PLAN EXAMINATION CONDITIONAL APPROVAL

PROJECT/SITE DESCRIPTION:
Maine Medical – Visitor’s Garage Extension

PROJECT ADDRESS:
22 Bramhall St – Portland, Maine

Review Type:	All Trades
Plans Date:	3/30/18
# of Sheets:	96
Project Area (sq. ft.):	82,201

6 PERCENT OPENING SUMMARY  
 SCALE: NONE

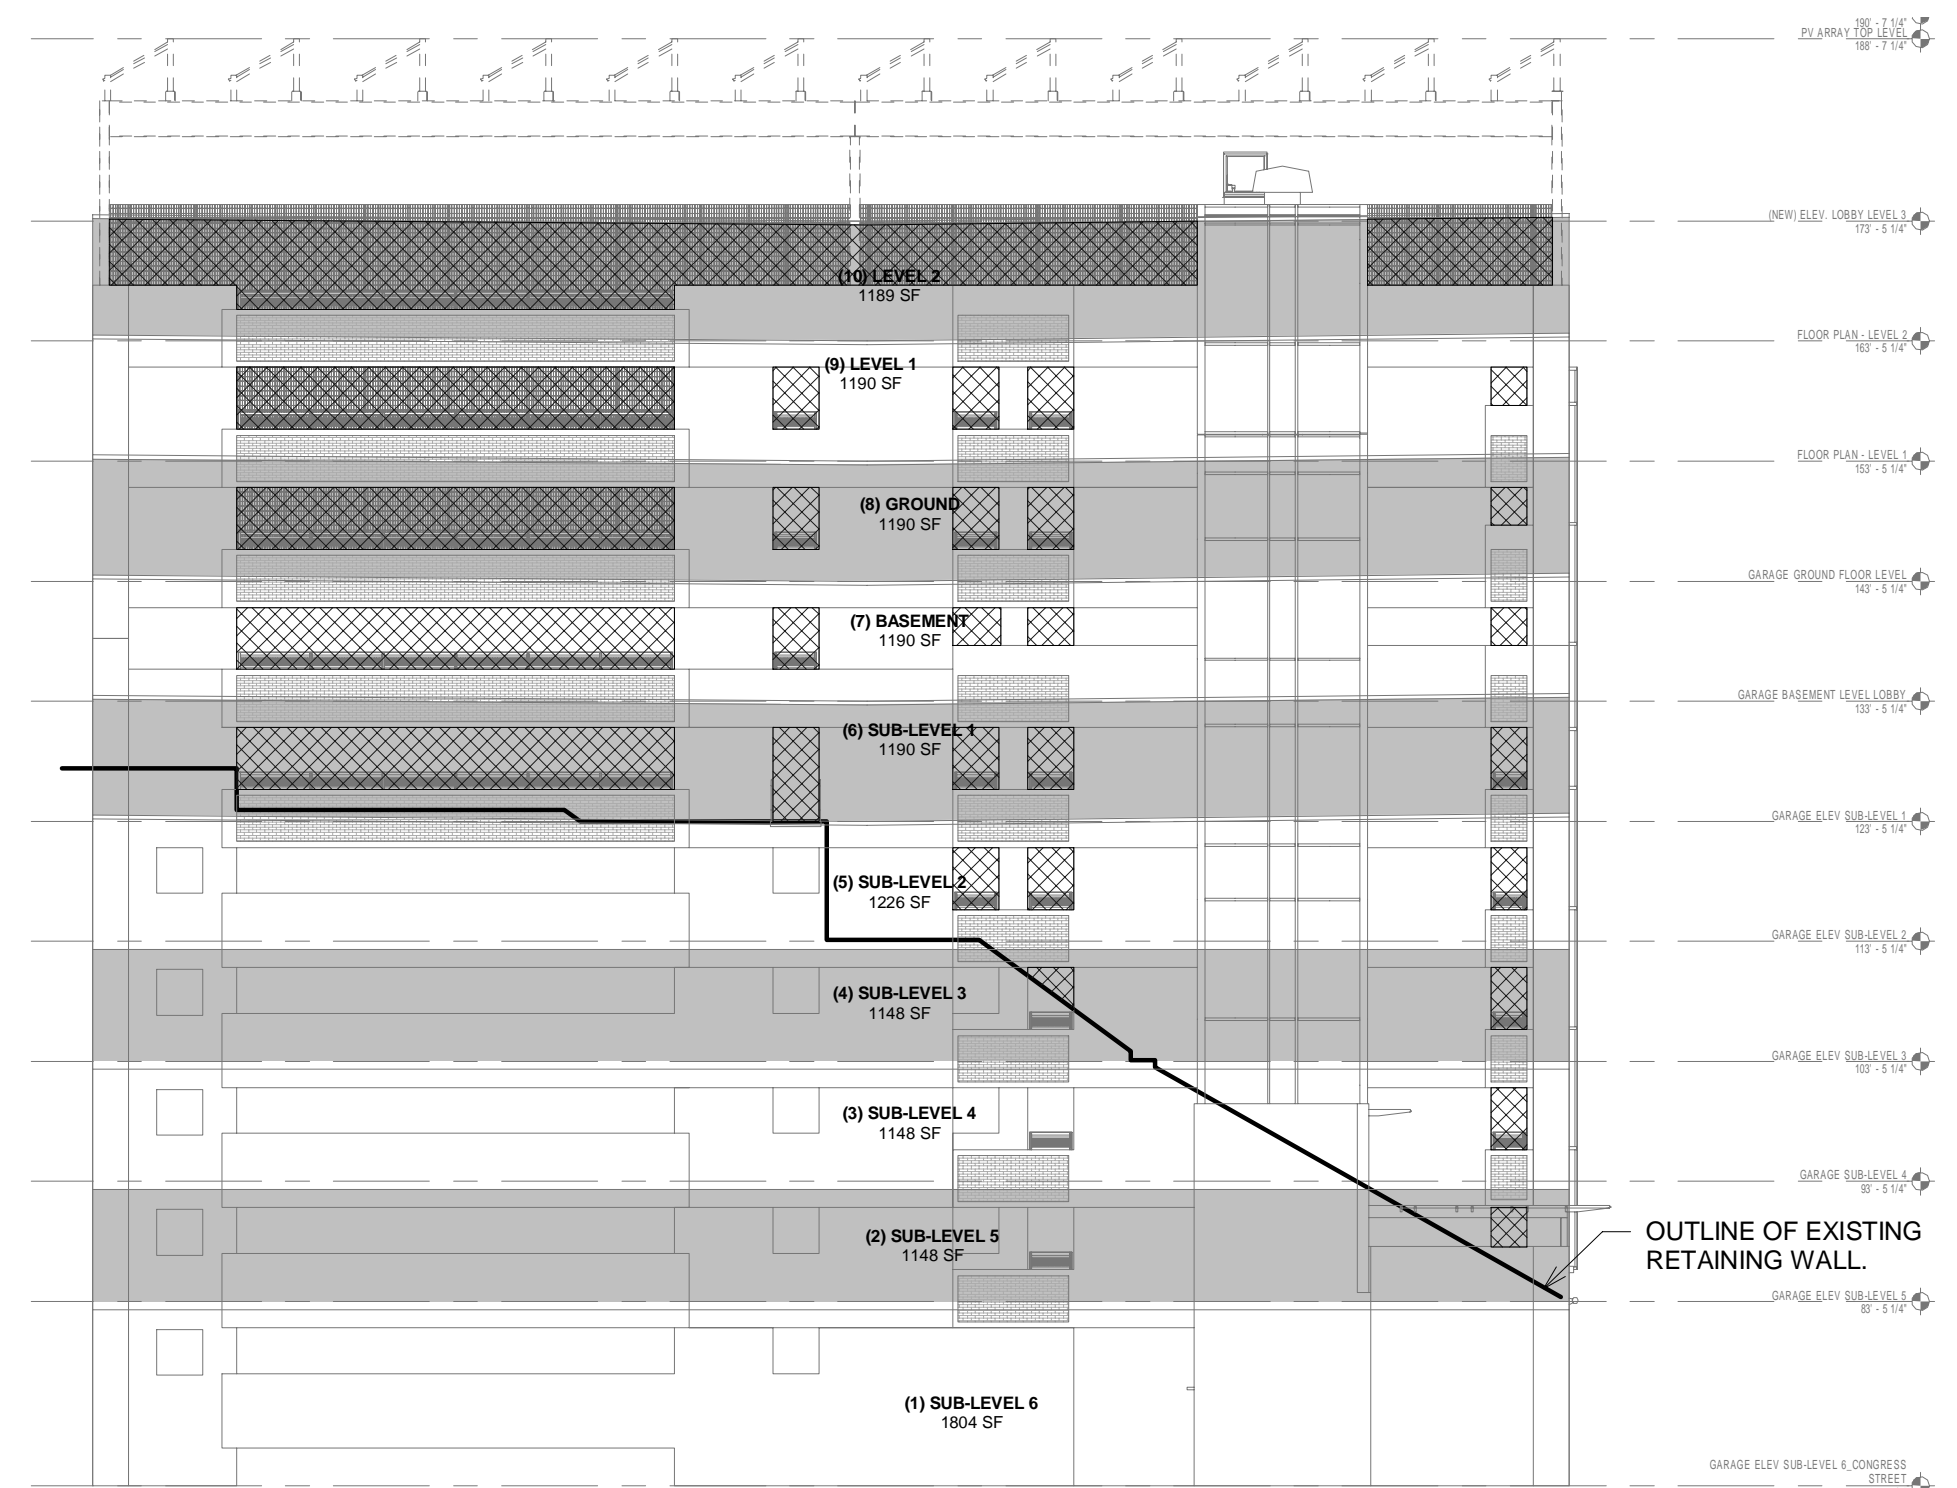
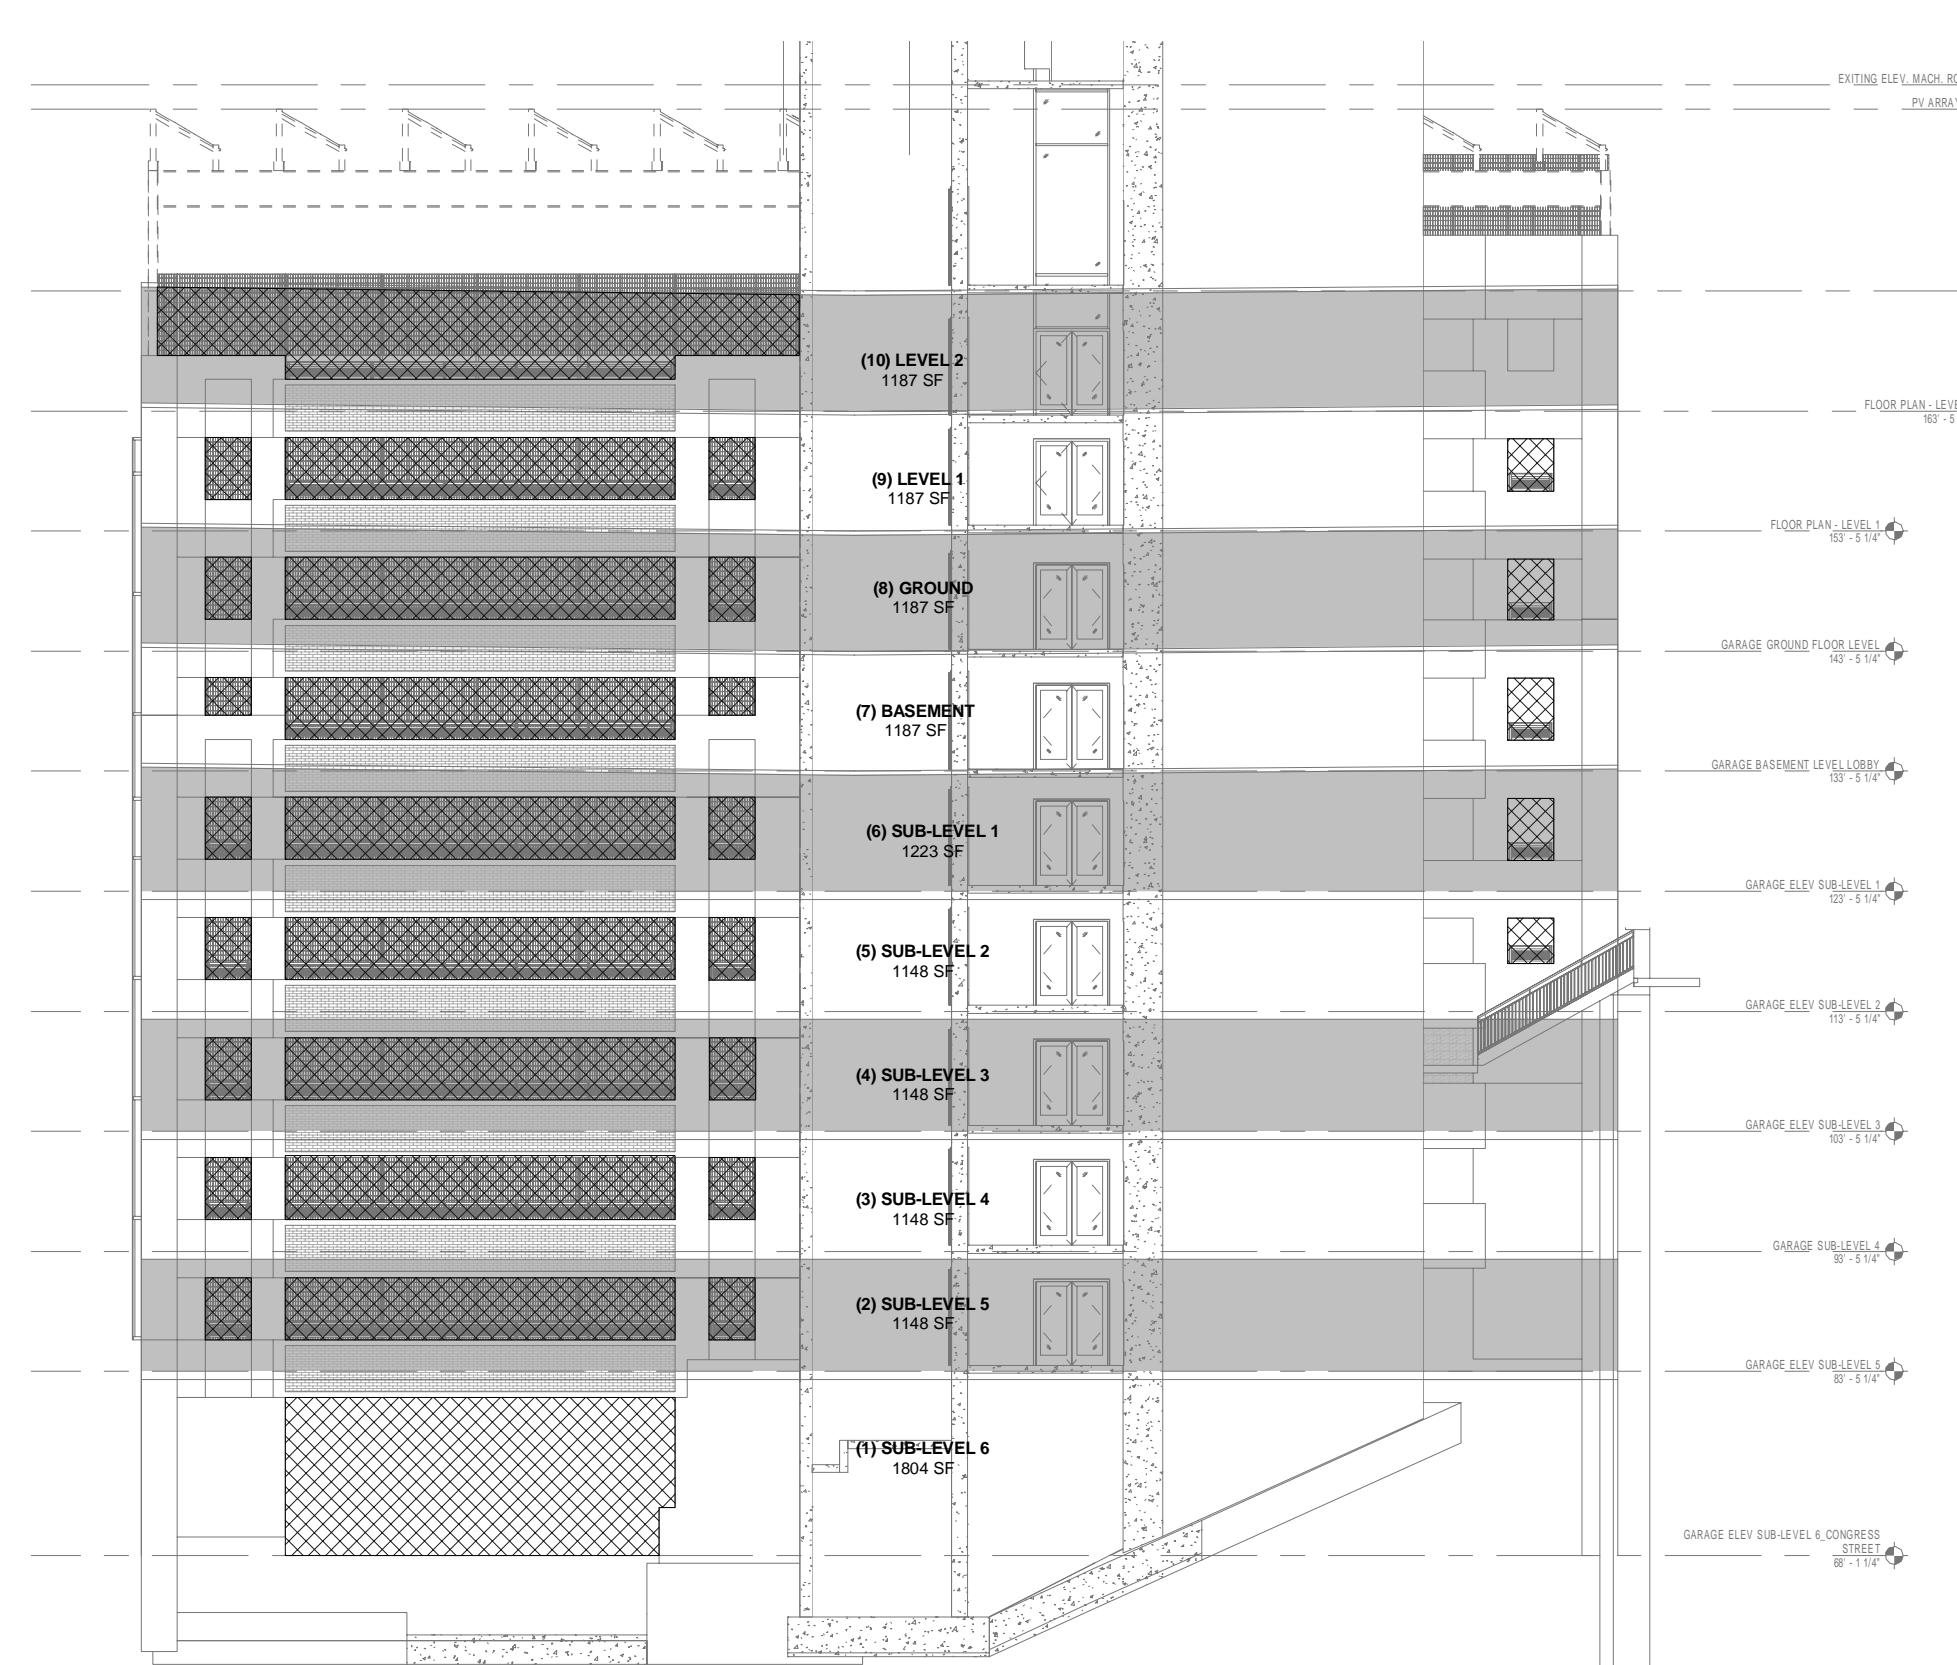
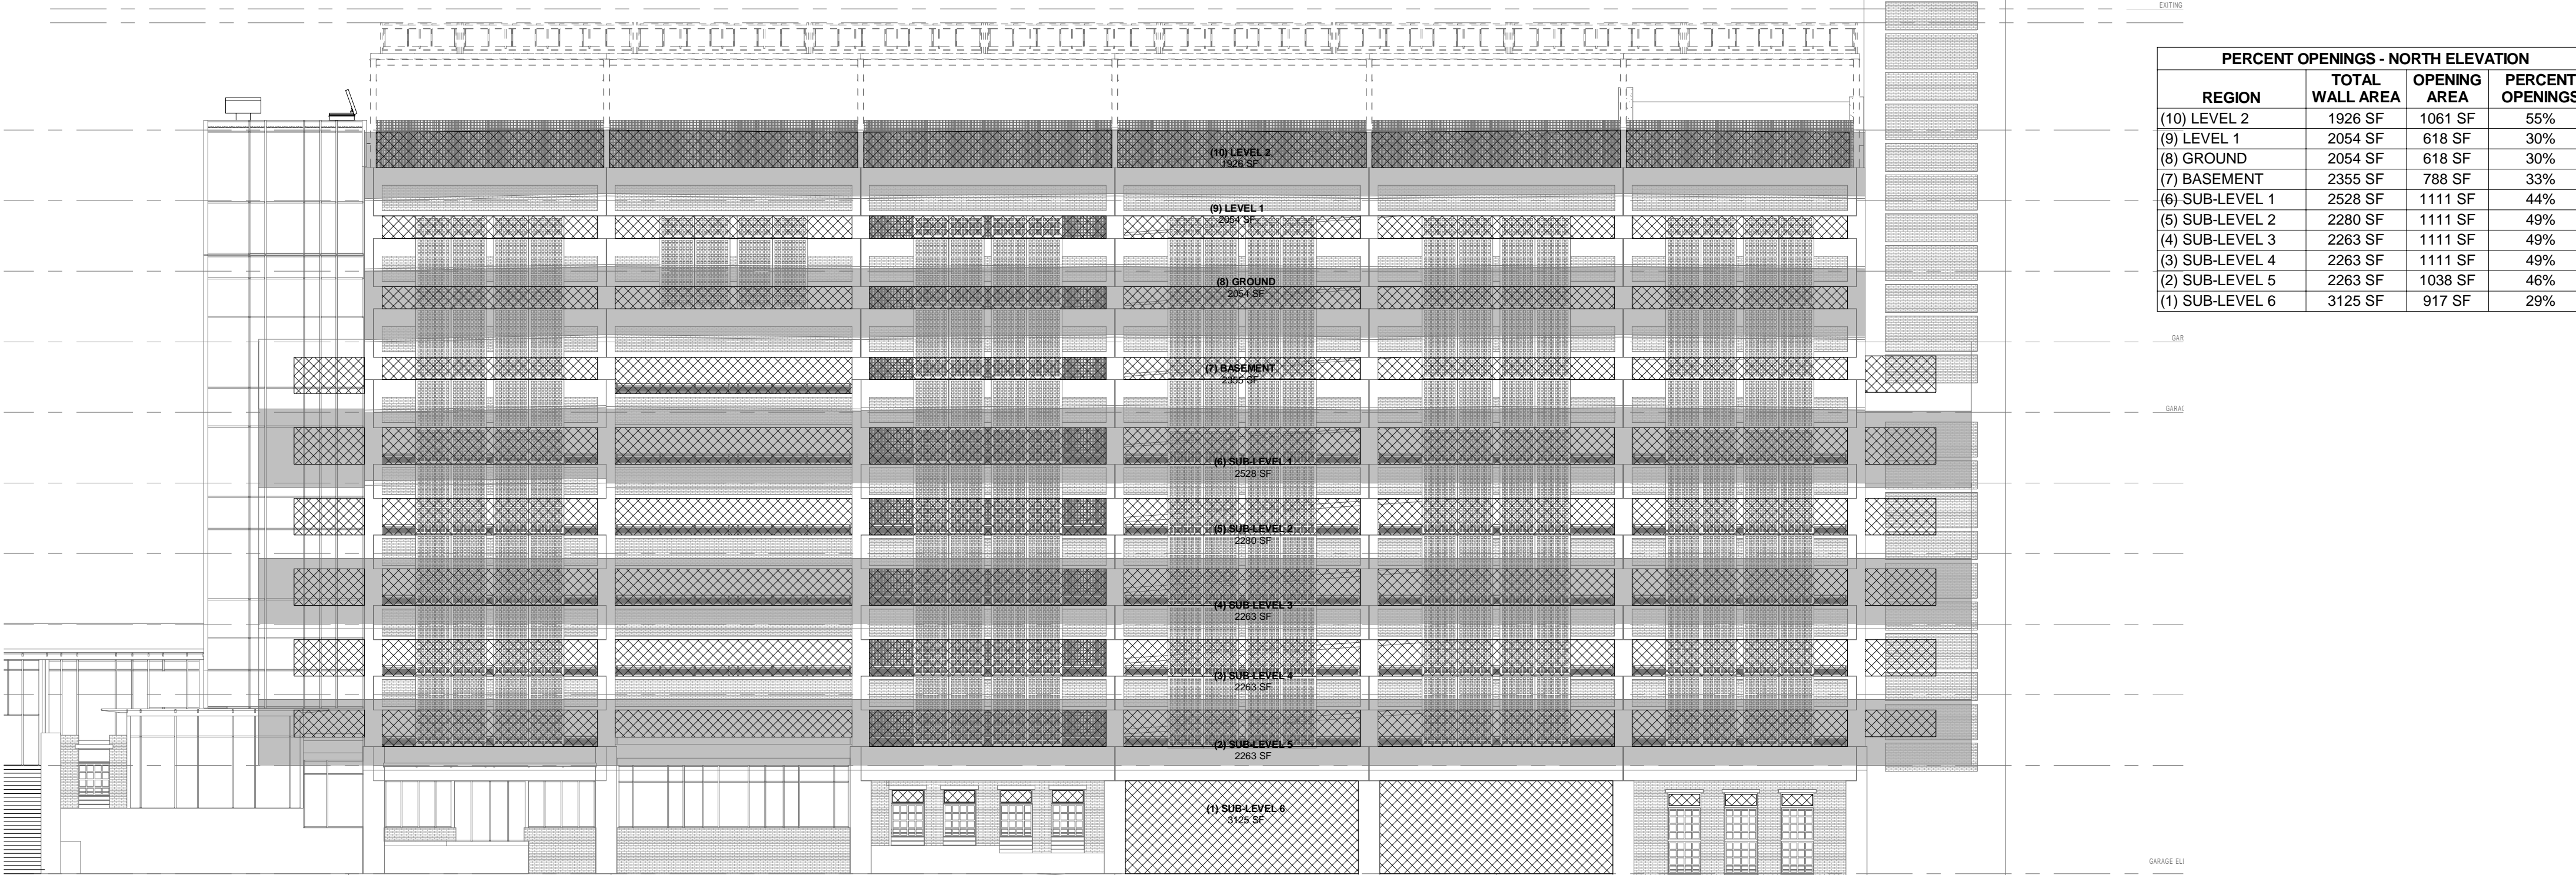
Plan Review Comments are based upon updated G02-01 Code Compliance Elevations sheets provided during review 3/27/18 demonstrating ventilation requirements meeting code requirements to allow for structure to be considered as an "Open Parking Structure".
